**State Significant Development SSD 6880 – Construct and operate resource recovery facility – 90 Gindurra Road, Somersby**

I refer to your email dated 26 August 2020 requesting comment from the Environment Protection Authority (**EPA**) in relation to SSD 6880 (**the Application**). The Application seeks to construct and operate a resource recovery facility to process 200,000 tonnes per annum of soils and building and demolition waste at 90 Gindurra Road, Somersby.

## **Attachment 1**

Figure 1. Site Location, Surrounding Area & Noise Logging Location

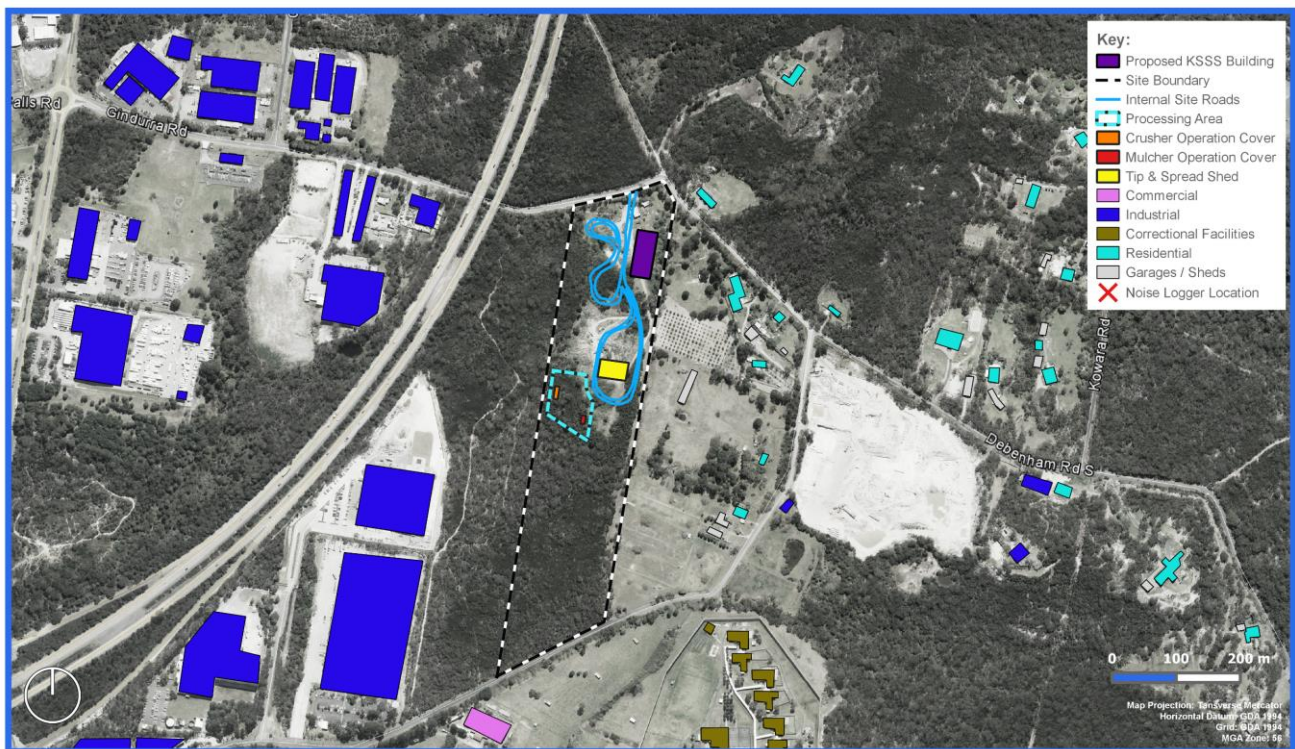
Ambient noise monitoring was undertaken on the boundary of the Kariong Sand and Soil premises and the adjoining residential allotment identified as 12 Acacia Rd Somersby as part of the original EIA. The NIA notes that industrial and traffic noise sources were the primary noise sources influencing the monitored noise levels. The major road and industrial sources appear to be located to the west of the premises. However, the most noise-affected receiver locations are located to the east of the premises with marginally greater separation distances, and potentially different exposure scenarios to the road and industrial sources.

- That the ambient monitoring location is representative of the ambient noise levels likely to be experienced at sensitive receivers located further to the east and at greater separation distances from the road and industrial noise sources;

- Determine whether noise from existing operations at the Kariong Sand and Soil premises influenced the monitored ambient noise levels at the monitoring location;

Figure 4. Tip & Spread Shed Design

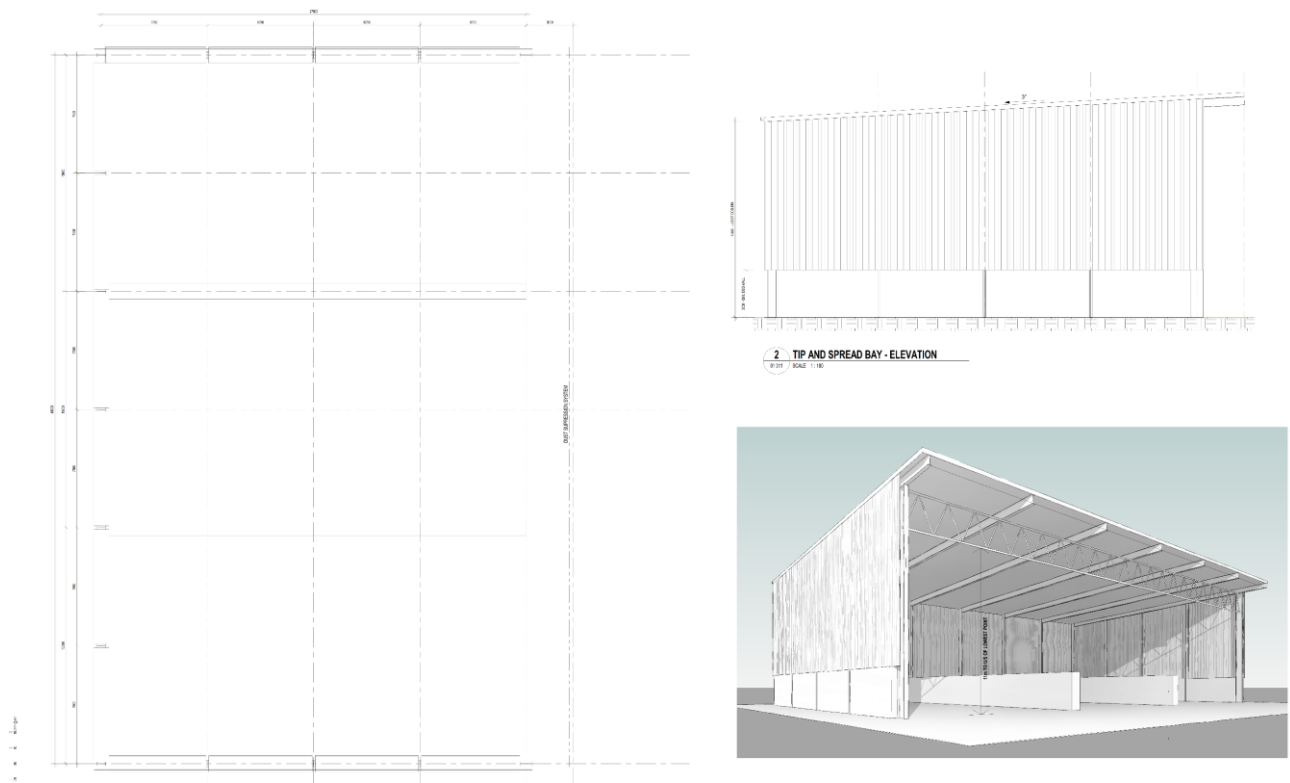
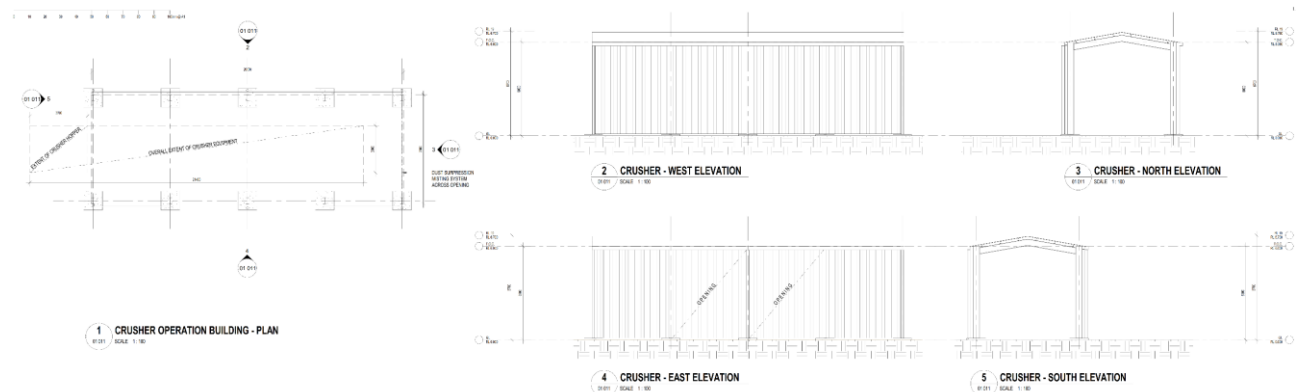
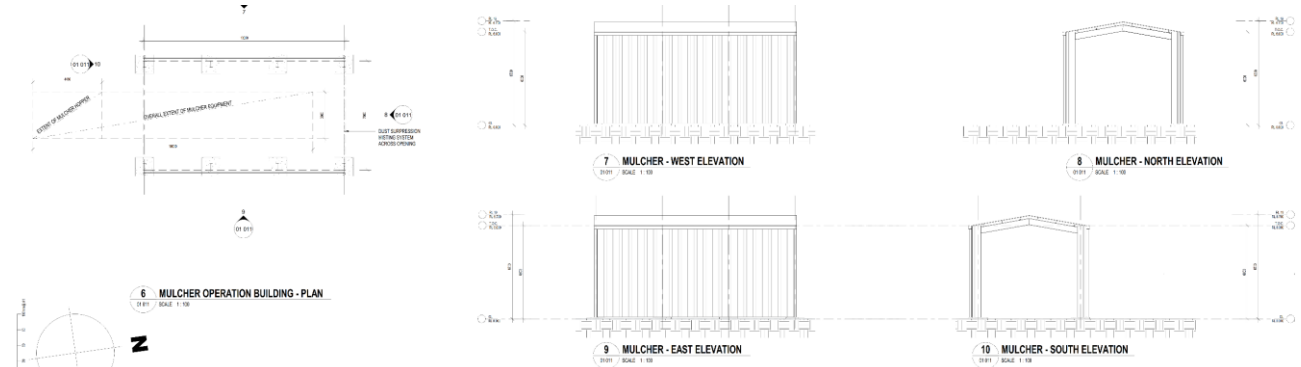
The EPA considers that partially enclosed structures, such as the ones proposed in the AQIA (V2, 2020), are not consistent with best practice emission control design. The achievable level of dust control using the proposed designs is expected to be low compared with a fully enclosed building, particularly under certain meteorological conditions and wind directions (dependent on the orientation of the structures). There is also no site representative meteorological data available which could be used to inform the optimal orientation of the building structures.

The EPA considers that the proposed engineering controls could be further improved using fully enclosed structures and should be considered in the final design stages for the proposal.

**Prior to project determination, the proponent should undertake a detailed feasibility assessment of engineering controls for controlling dust, including a benchmarking study against best practice dust management. The assessment must consider the adoption of fully enclosed structures around all key waste processing activities.**
